Our ref: P18-587-L02v1
7 January 2019

**Re: West Midlands Interchange, Four Ashes
Review of ES Noise Chapter & Addendum Report**

Figure 13.4: NIR 1975 Assessment Locations

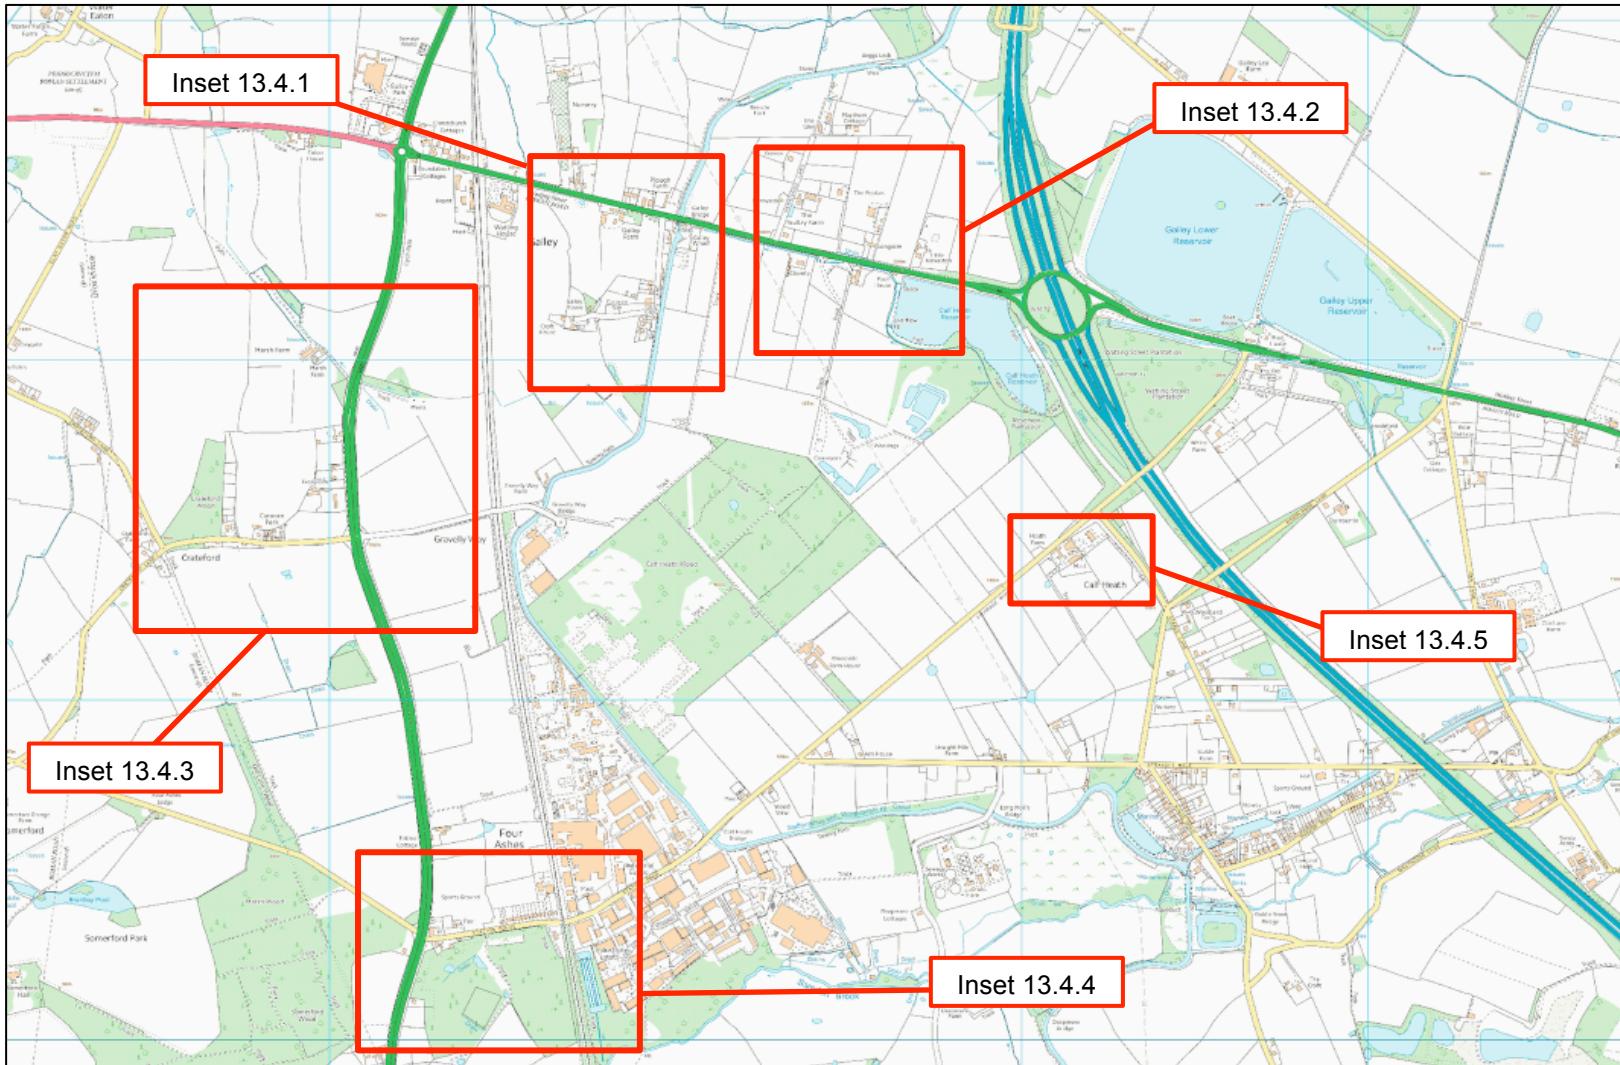
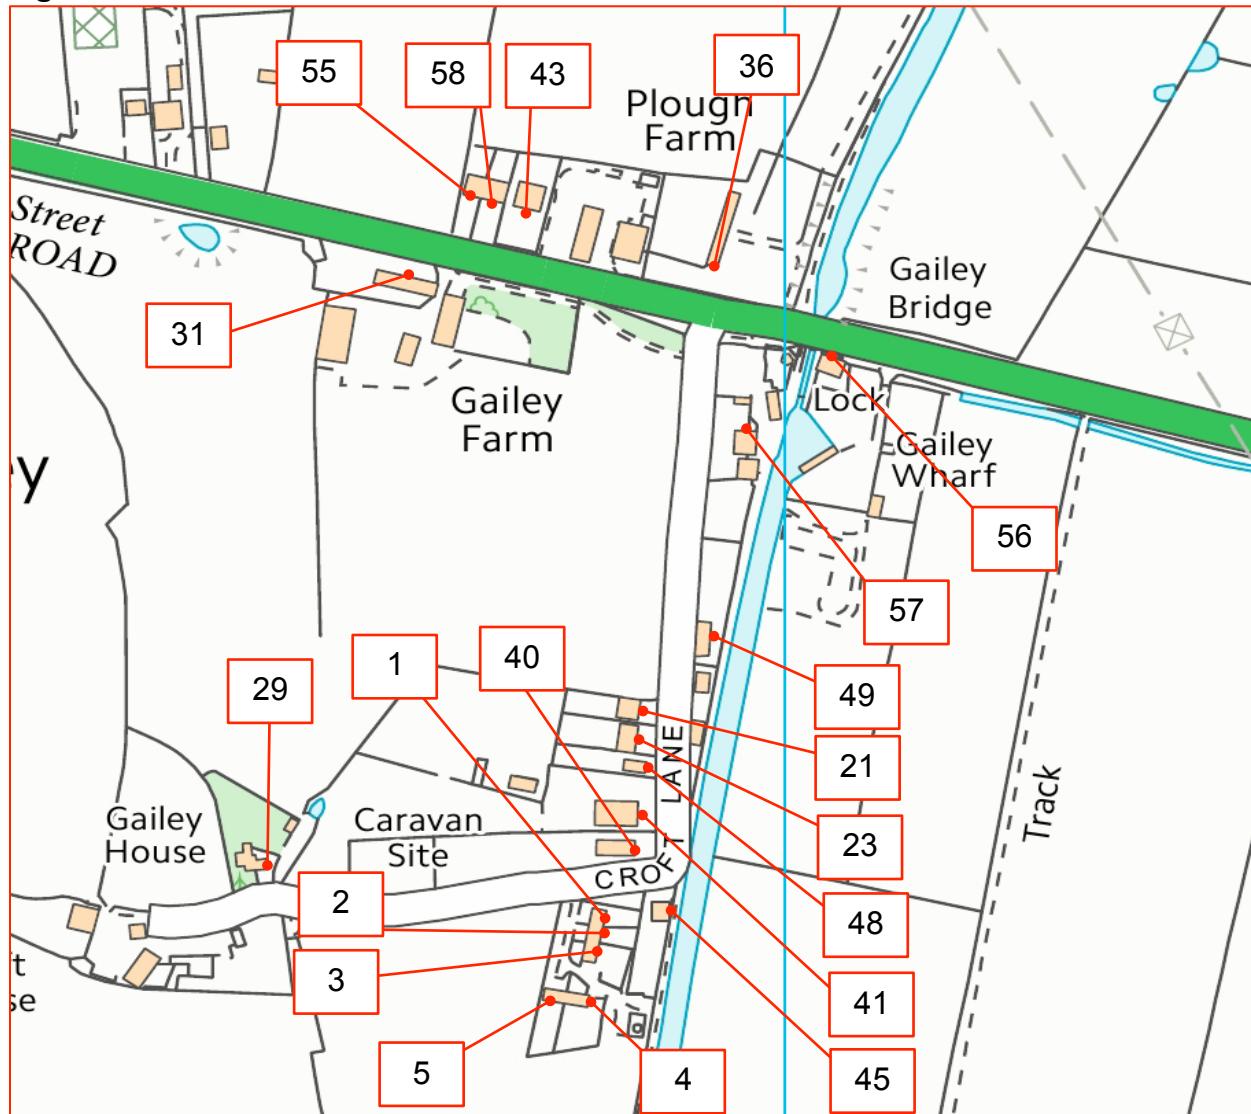
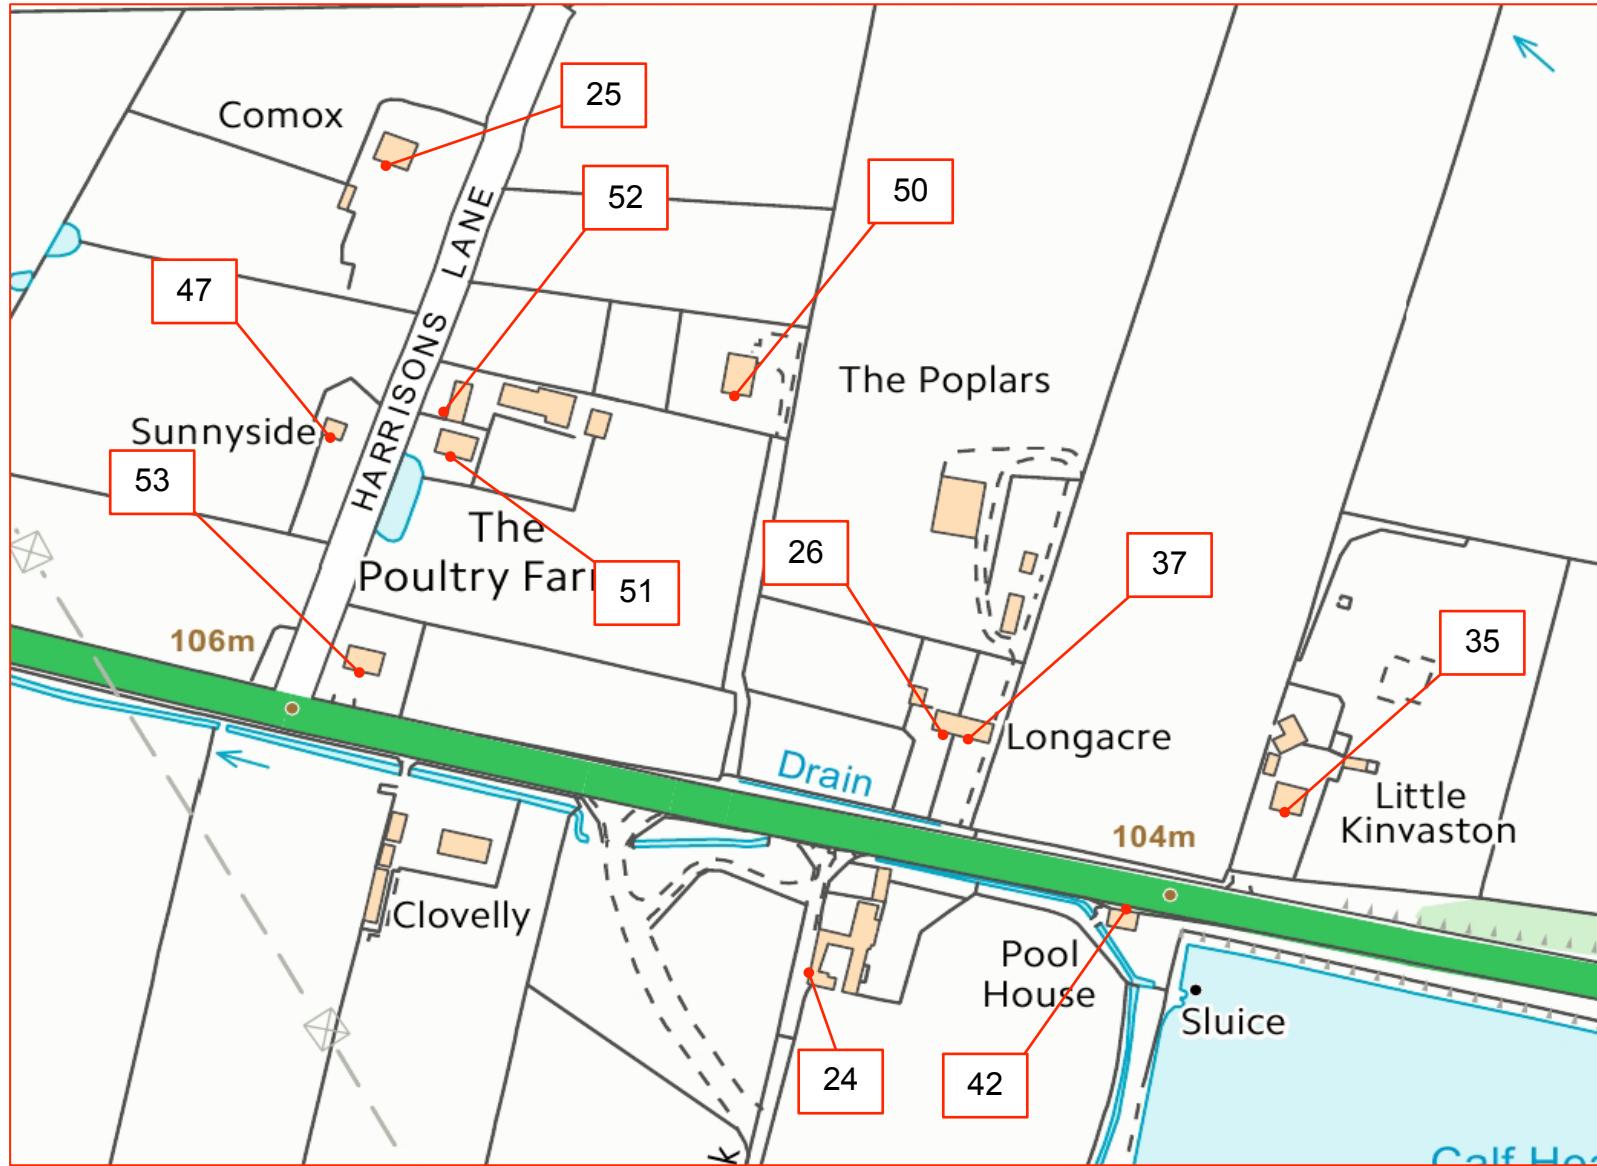
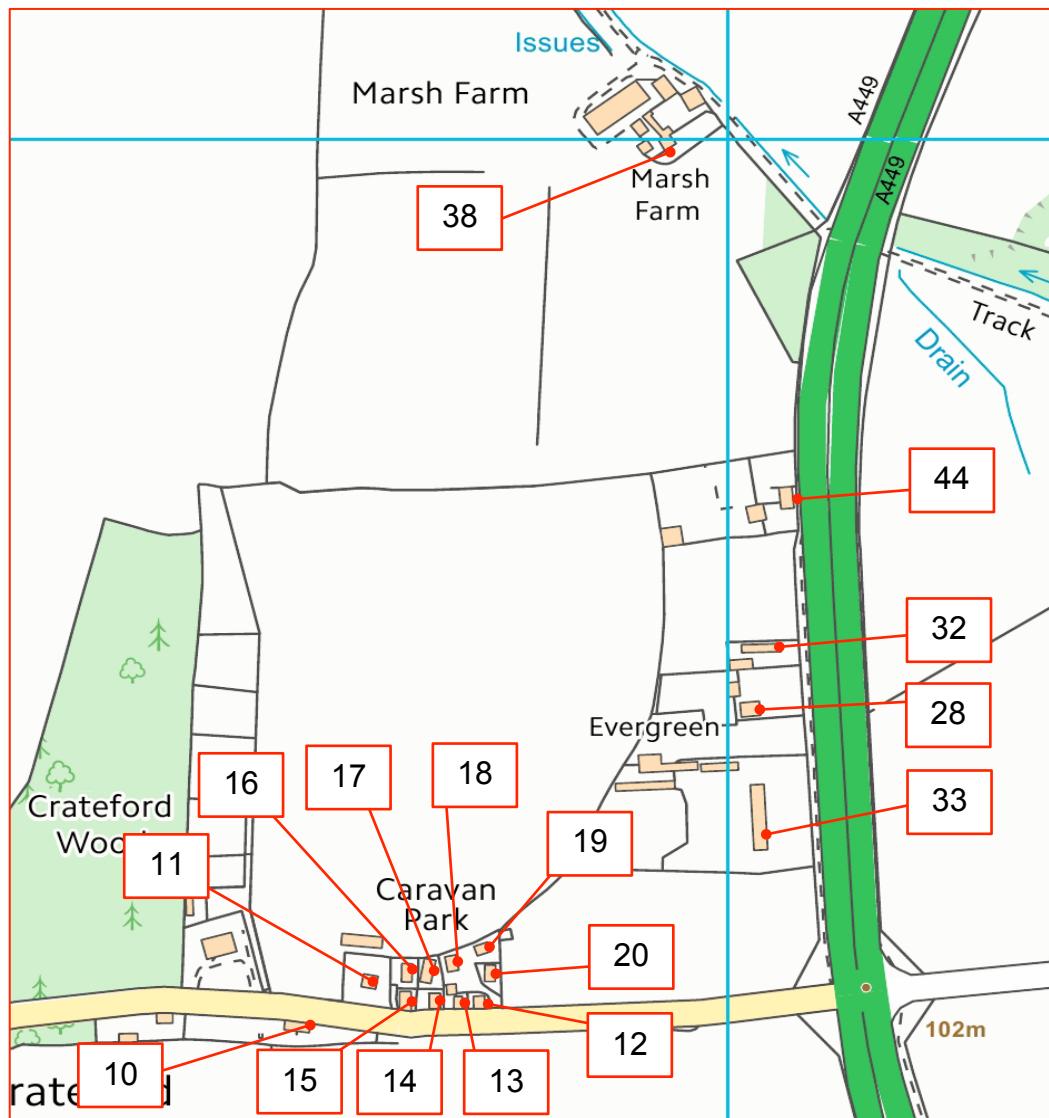
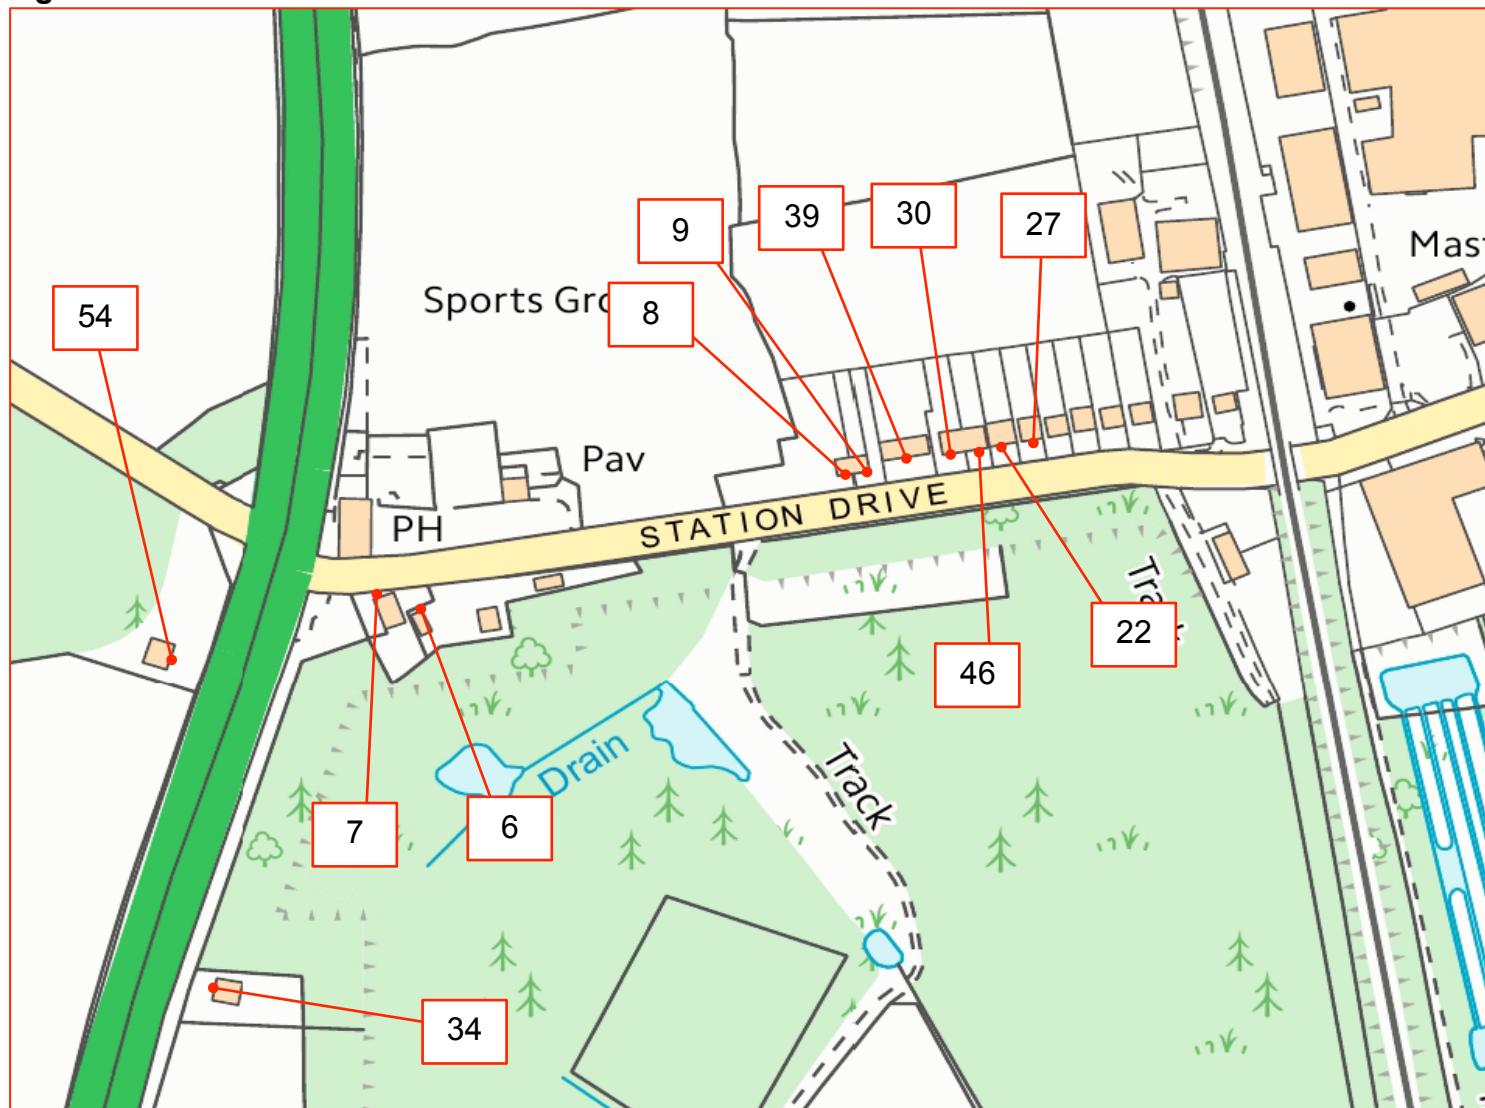
12. The significance of noise impacts are described in the National Policy Statement for England (NPSE) which is summarised in the noise chapter. This document introduces the concept of NOEL, LOAEL and SOAEL albeit without attaching numerical values. This concept is described further in the online National Planning Practice Guidance as summarised in the noise chapter. In the noise chapter RAL are at pains to explain their interpretation of gradations above SOAEL ('significant observed adverse effect level') which is summarised in 13.51. RAL state that they consider 'unacceptable' SOAEL to occur only at very high levels which would trigger NIR 1975 and NIR 1996 sound insulation schemes. We do not agree with this
